Recommendation Report for Planning Permission for Works or Extension to a Dwelling

REF NO: R/136/19/HH

LOCATION: 84 North Lane
Rustington
BN16 3PW

PROPOSAL: Two storey side extensions, new roof, single storey side extension, single storey front extension and single storey rear extension.

Drawing
Proposed floor plans

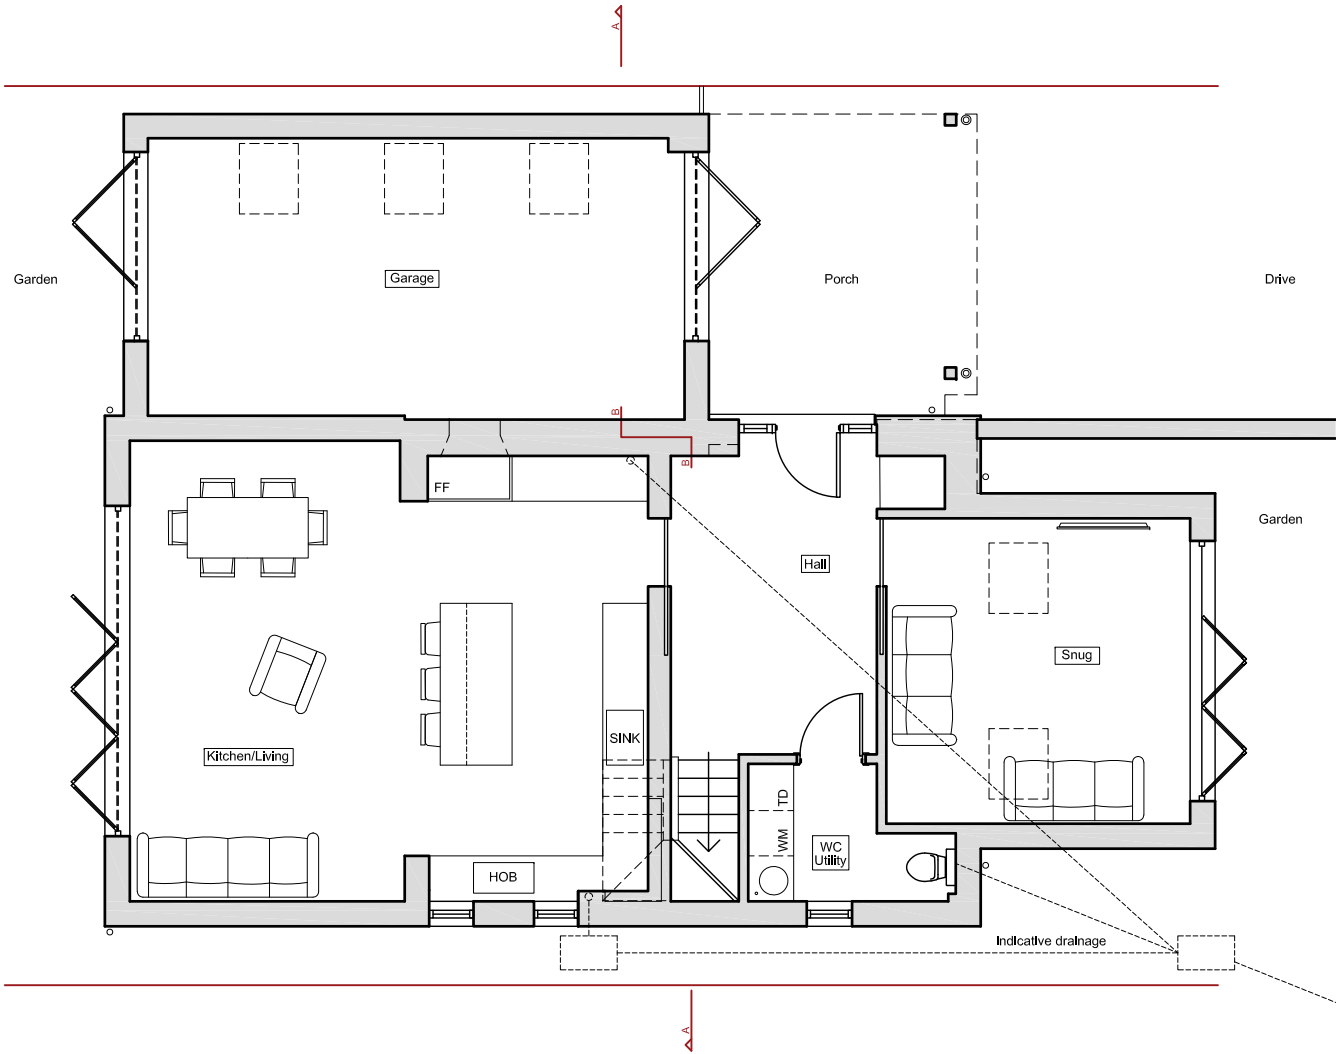
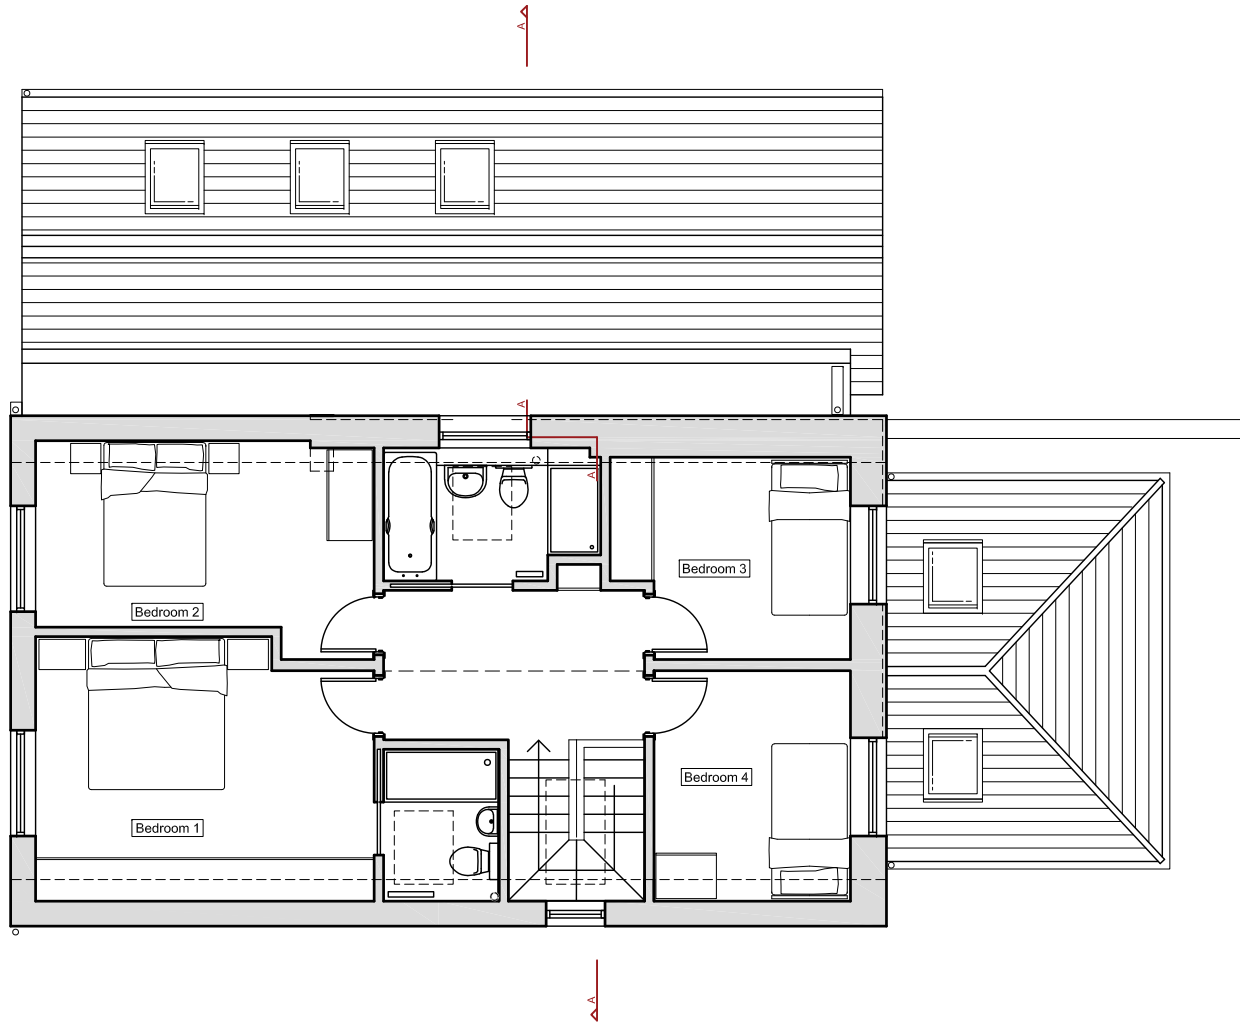
The proposed side extension, to be used as a garage, will be visible from the street scene, as a result of

its siting. Whilst the proposal is considered to comprise a change to the appearance of the host dwelling, it is not considered to have a harmful impact on the character of the host dwelling. Due to its configuration, the extension will not extend beyond the existing Easternmost (front) projection of the host dwelling. Resultant of this, and its scale and design, the proposed development is considered to appear well integrated with, and subservient to the host dwelling. Due to the boundary treatment at the front of the site, there will be few views available of the proposed front extension from the public realm. This is considered to allow this element of the proposal to have no significantly harmful impact upon the character of the locality, or the host dwelling.

Proposed north side elevation

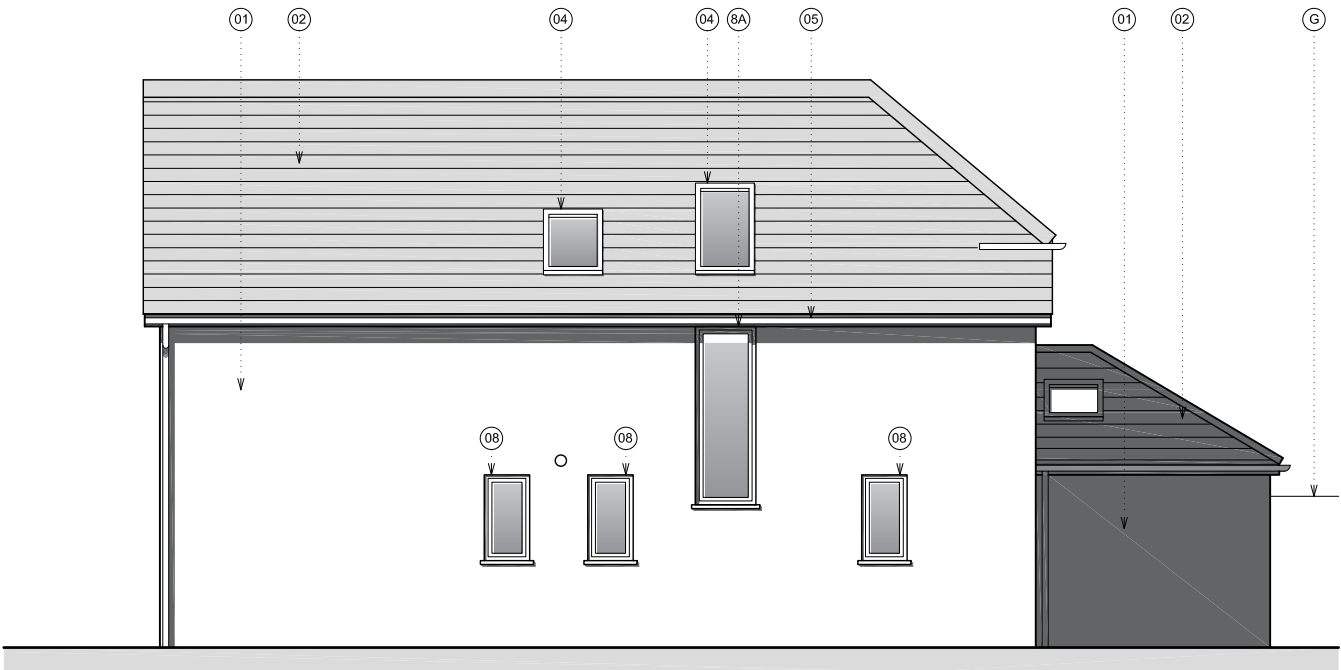
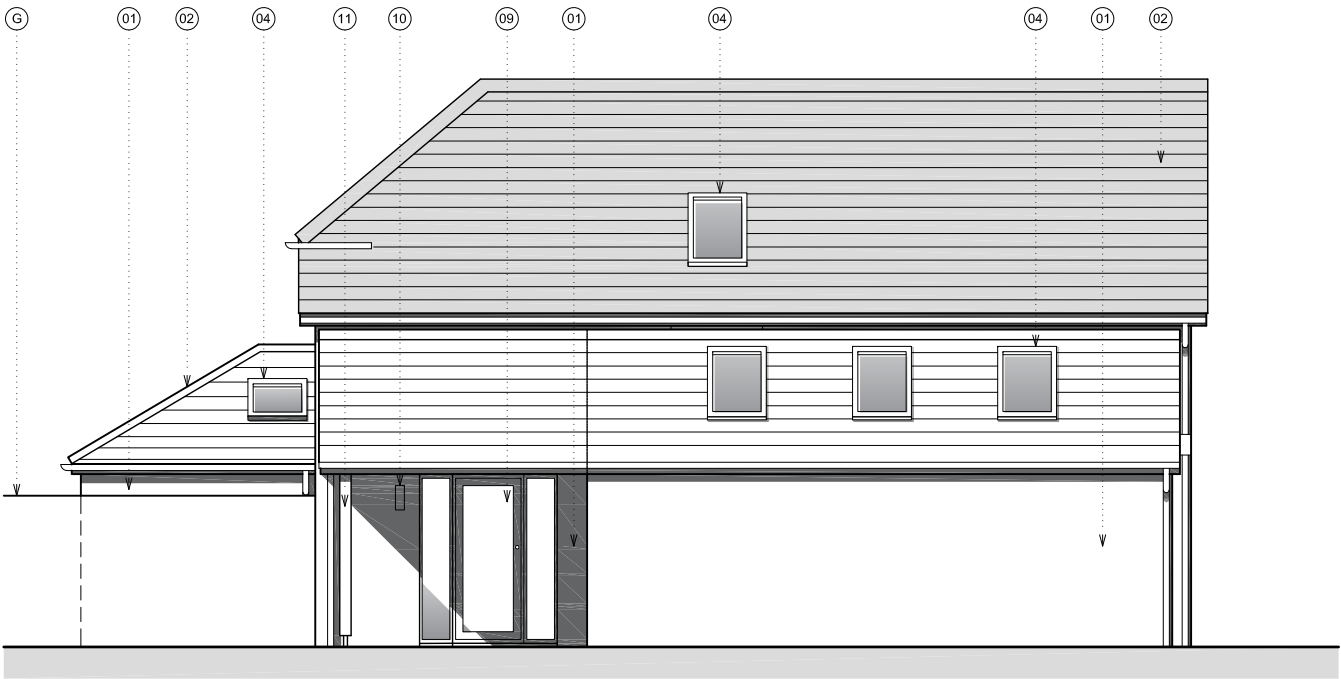
The proposed development is not considered to give rise to any significant impact on the residential amenities of neighbouring dwellings. Whilst the distance between the proposal, on the Southern side, is noted to be reasonably close to the adjacent dwelling, it is not considered that this would have any significantly harmful impact upon the residential amenities, as the proposal slopes down to an eaves height of 2.5m, when adjacent to this boundary. With regard to overlooking, the proposed development is not considered to result in any loss of privacy to adjacent occupiers, in that most of the proposed openings are at ground floor level, and therefore, provide views that are no different to those existing from the application site at current. There are proposed openings are first floor level, however, to the East, and West, these are not considered to result in any change to views available. To the North and South, there is only one window which has potential to result in a loss of privacy, which is shown as obscure glazed, on the submitted plans.

- 3 The window on the first floor, Northern elevation of the building shall at all times be glazed with obscured glass and fixed to be permanently non-opening.
